SECTION 4.55 (1A) APPLICATION TO AMEND SSD 10437 - WATERLOO METRO QUARTER OSD SOUTHERN PRECINCT

This letter has been prepared by Urbis on behalf of WL Developer Pty Ltd (the applicant) with regards to a Section 4.55(1A) application to modify State Significant Development (SSD) Waterloo Metro Quarter OSD Southern Precinct SSD-10437.

The modification application seeks for minor internal and external design changes to Building 3 and the landscaping. The majority of the proposed changes are internal and considered to be minor. The external changes relate to minor landscape changes, configuration of rooftop plant and inclusion of additional louvres.

Elevation - North

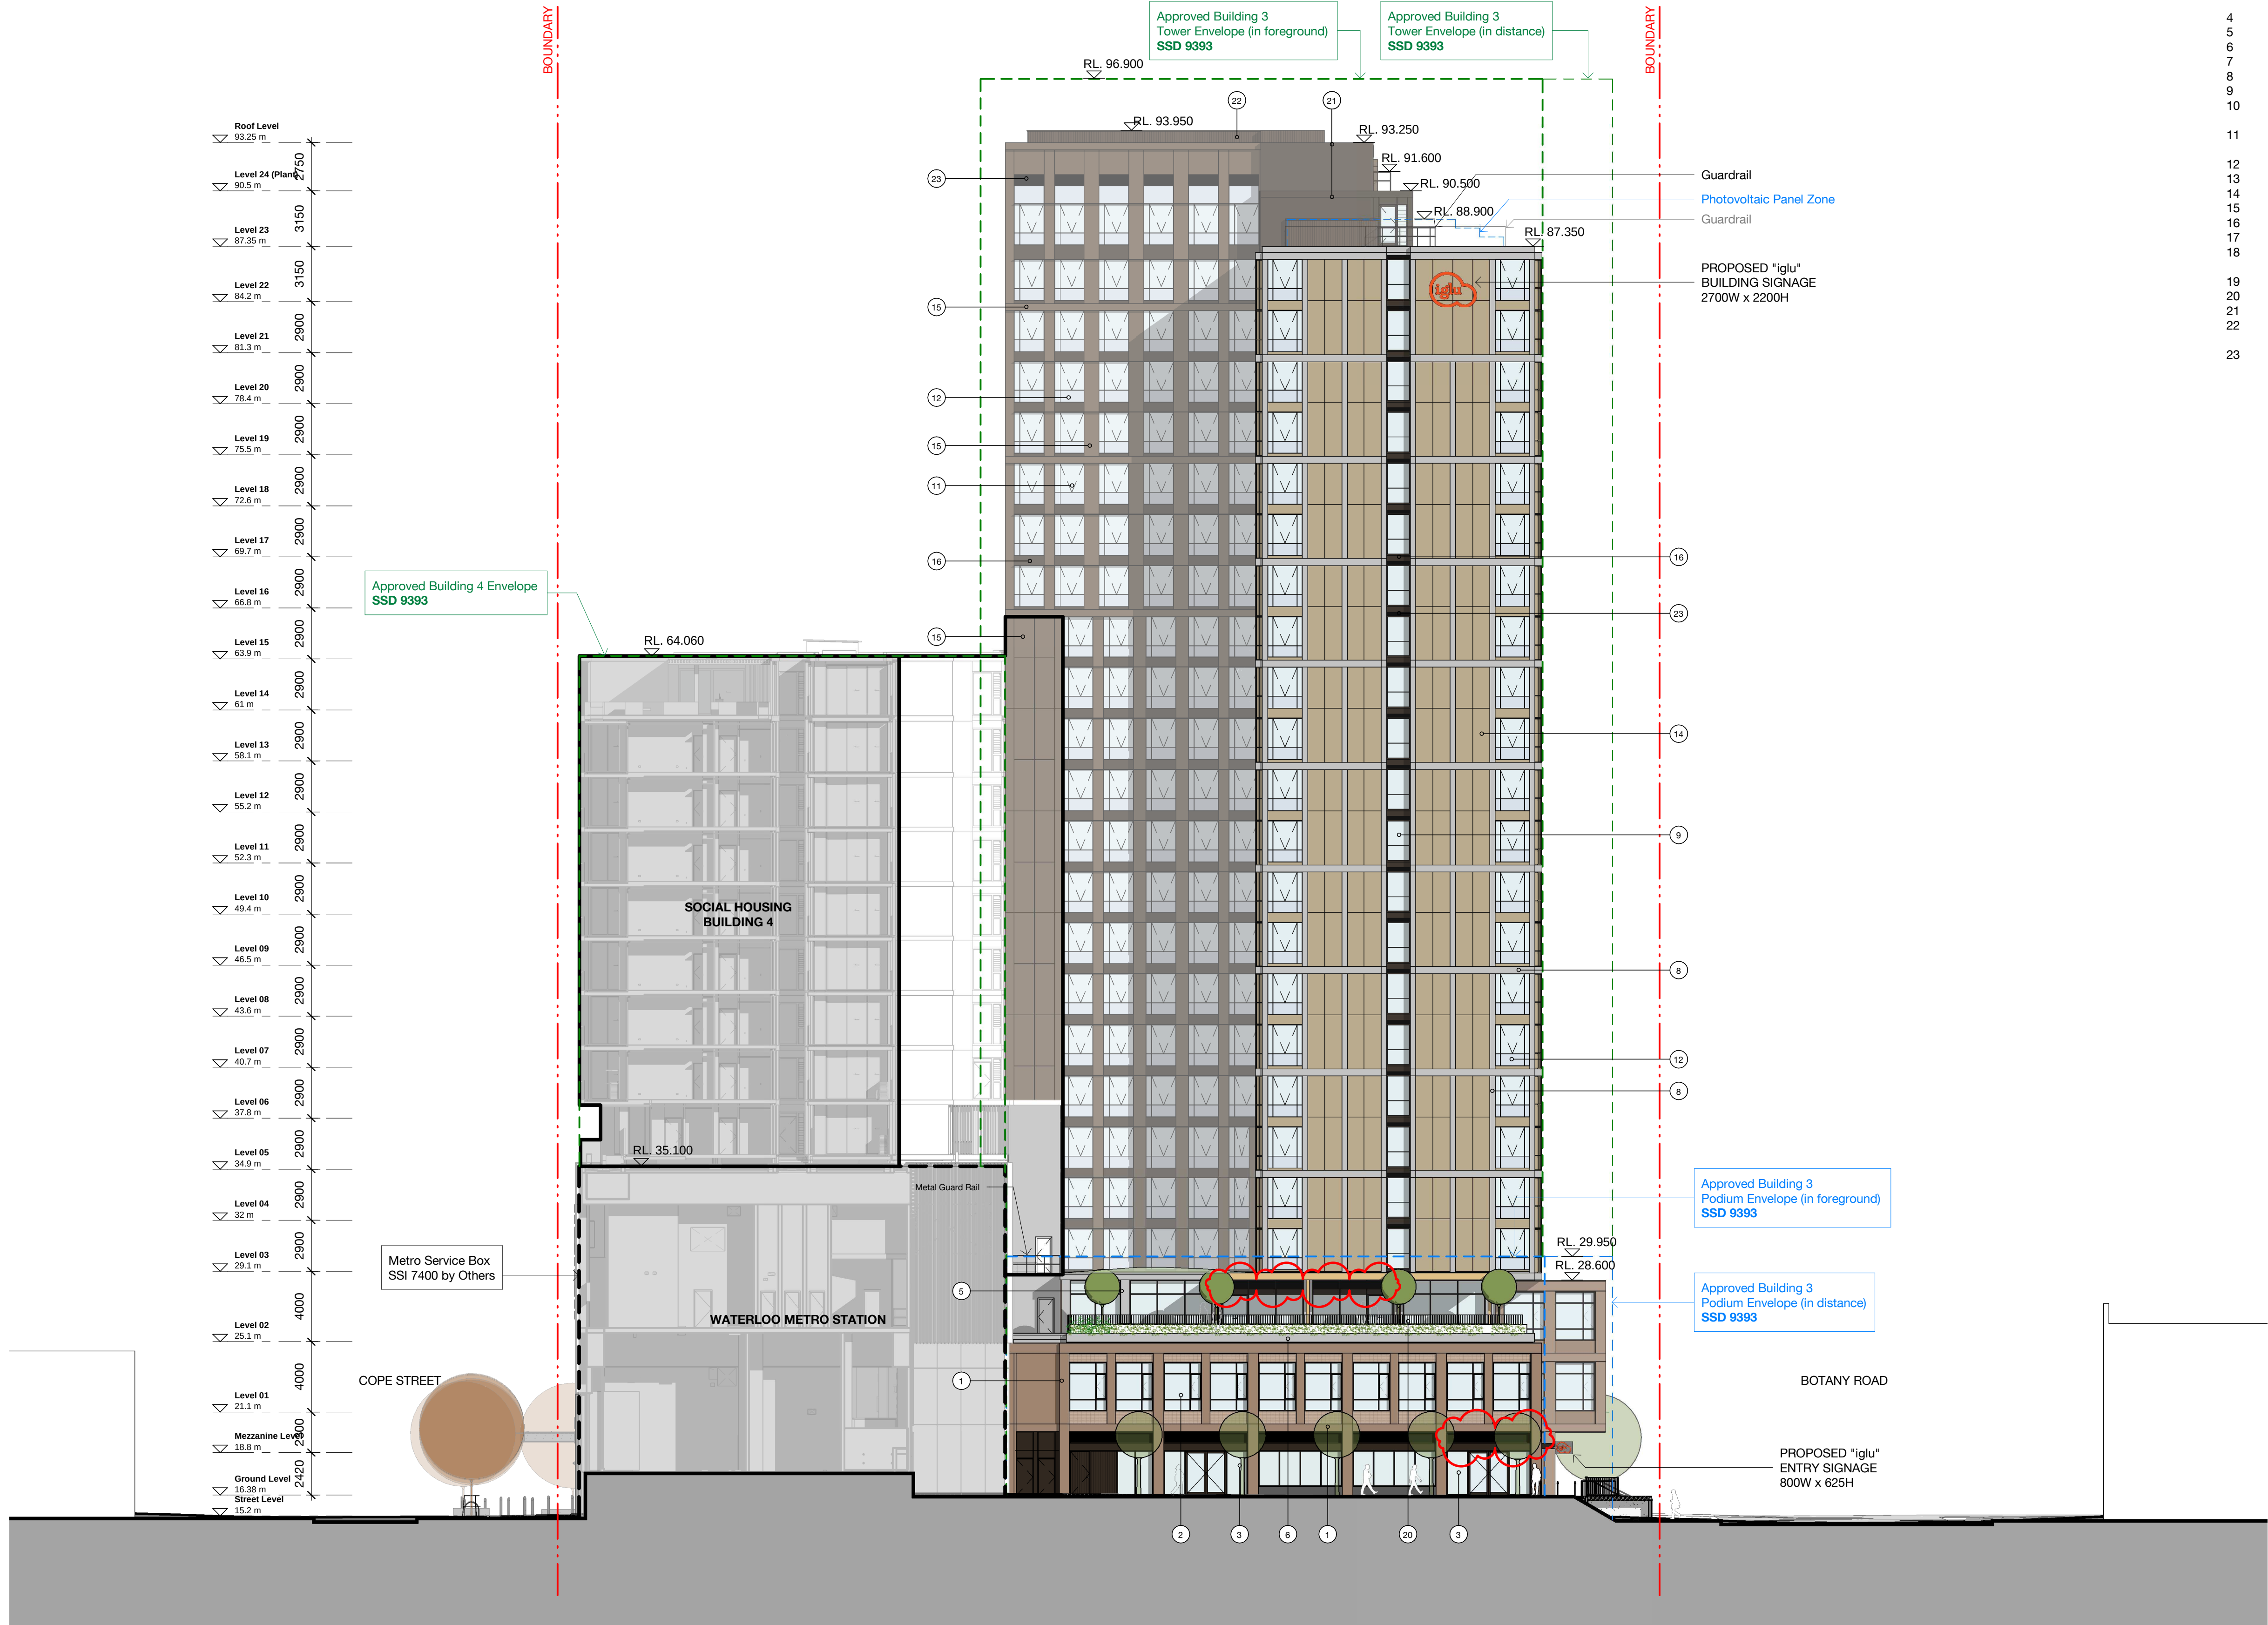
- Revise roof plant zones
 - Increase height of plant zones, not exceeding the approved Concept building envelope (RL96.9) (see below comparison of plans);
- Addition of louvre for ventilation on western elevation to Level 24 lift core
- Additional service doors to podium roof
- Addition of louvres to podium of the mezzanine level and Level 1.
- Addition of louvres to northern elevation of the ground level and Level 2

Section E-W

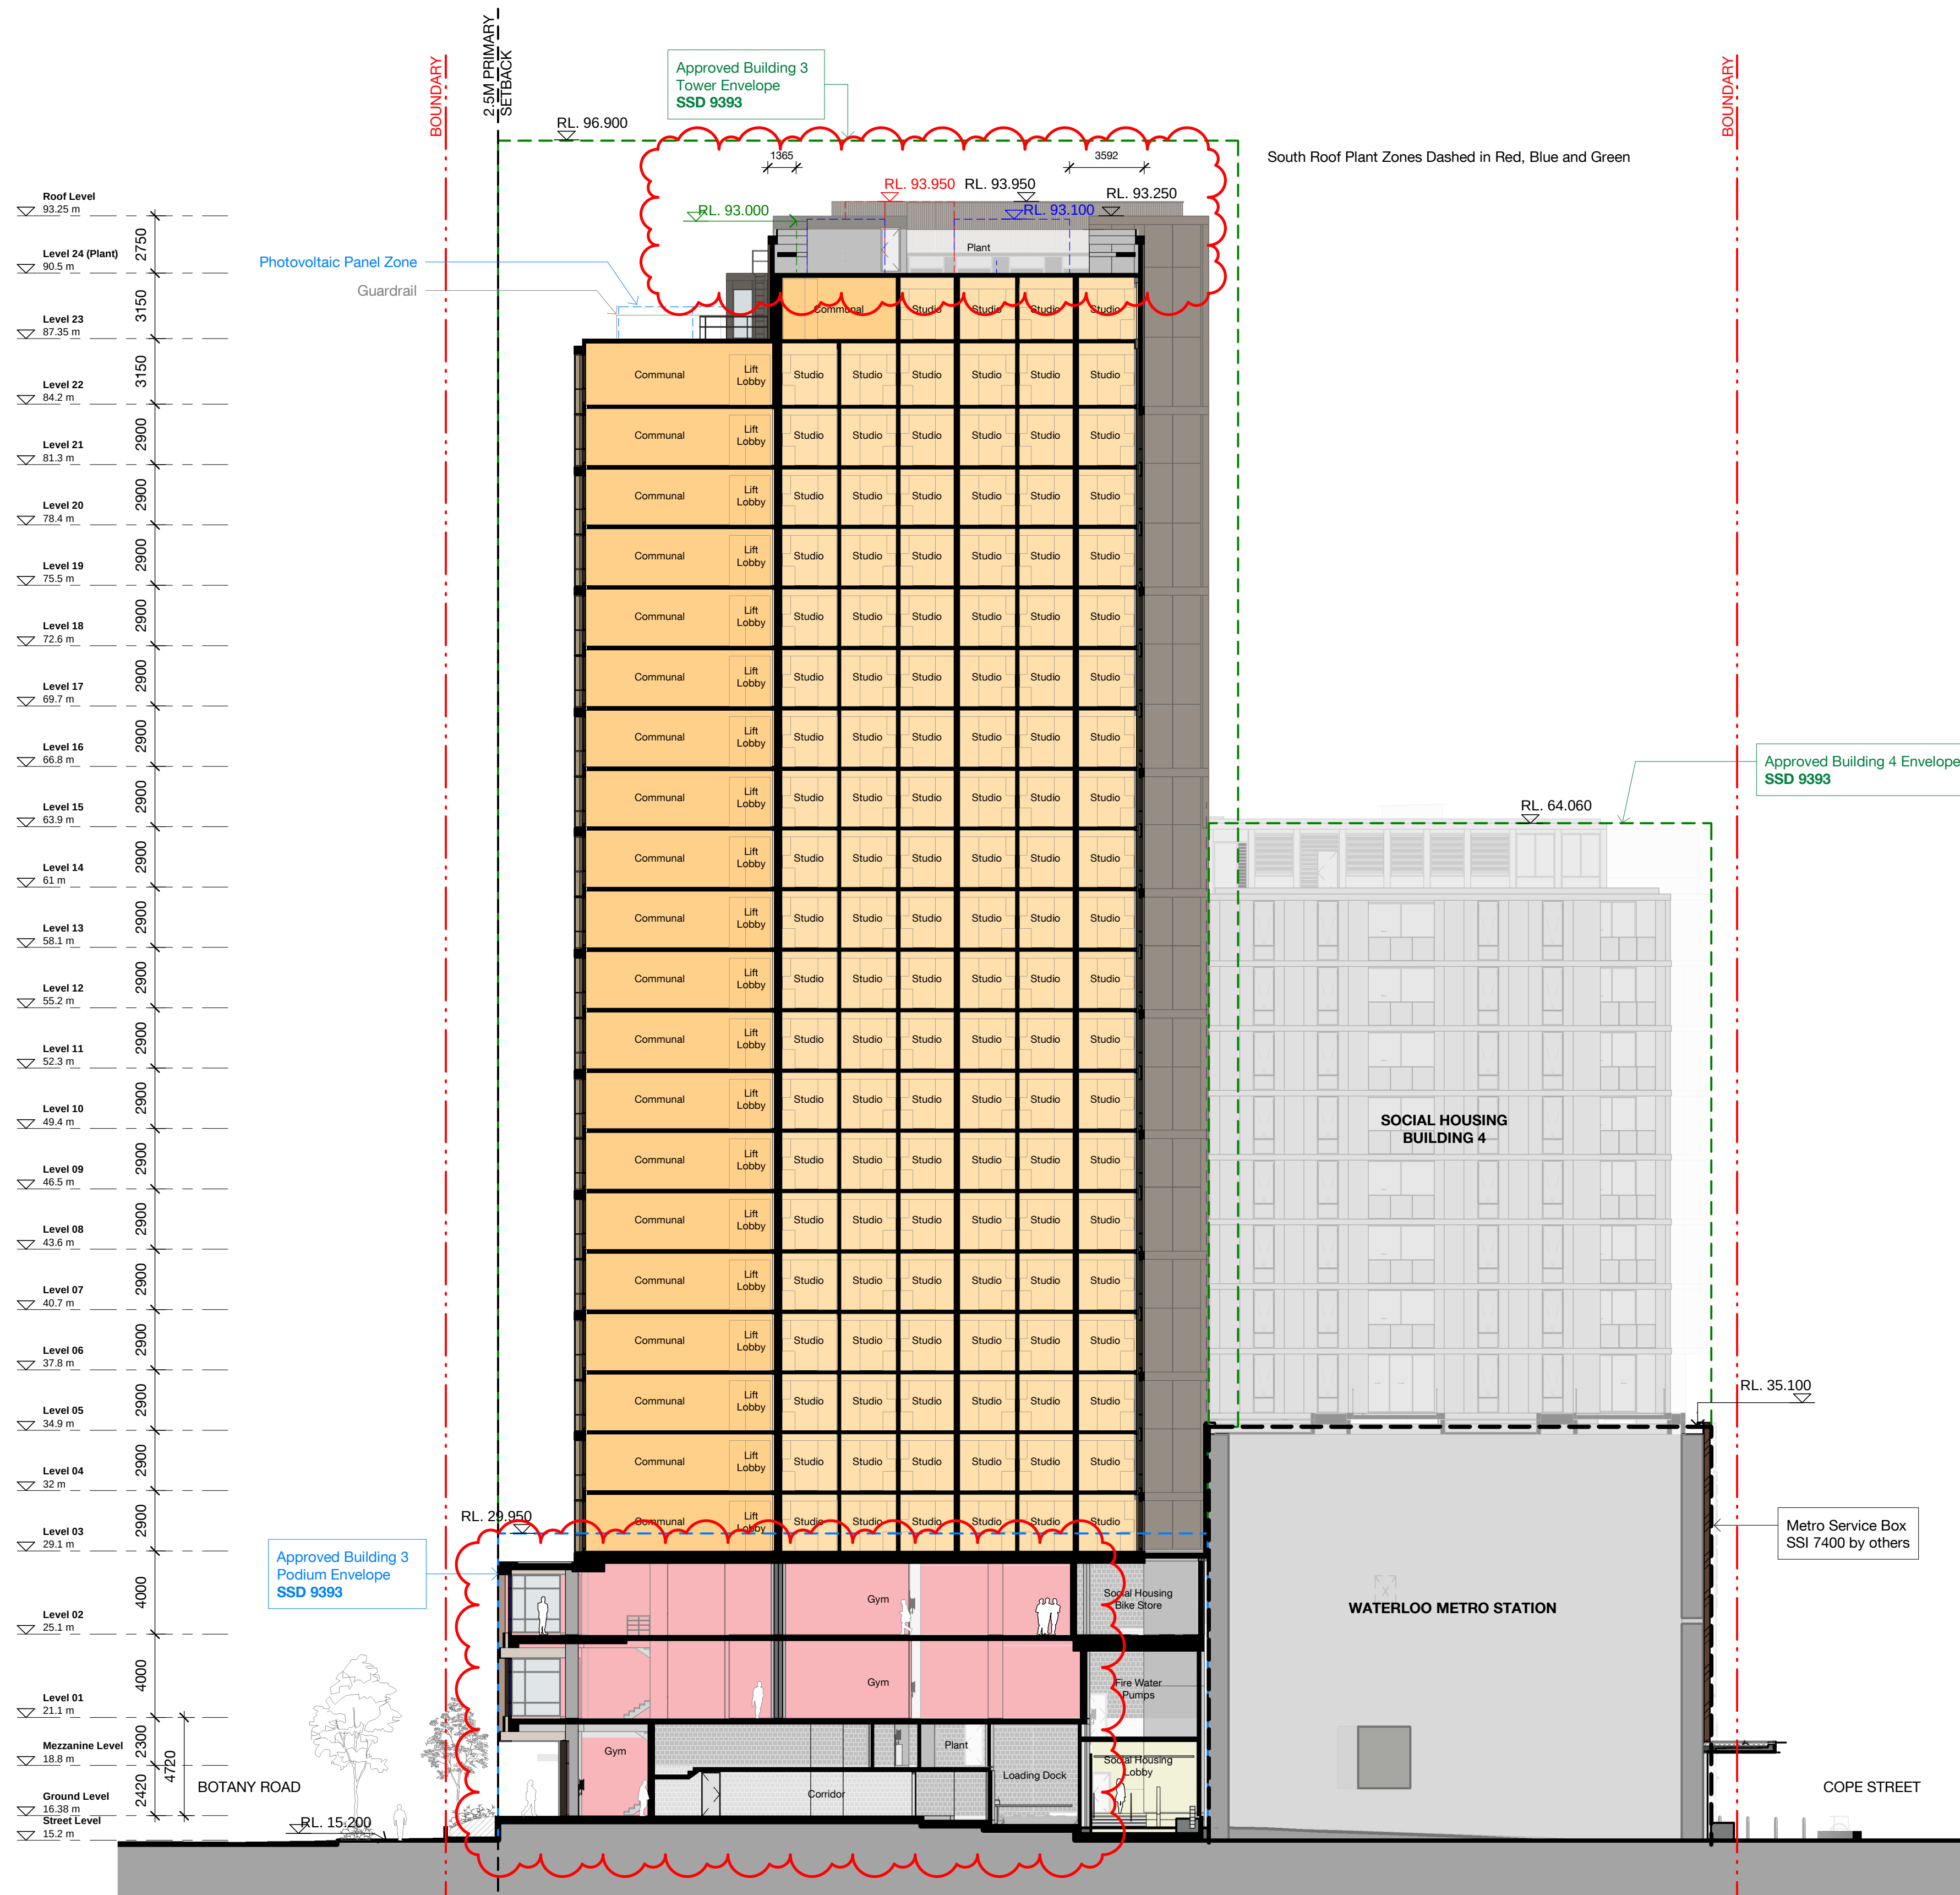
- Student accommodation – reconfiguration to the core and services areas.
- Gym – lift and stair reconfiguration
- Addition of block wall and boom gate to loading dock driveway
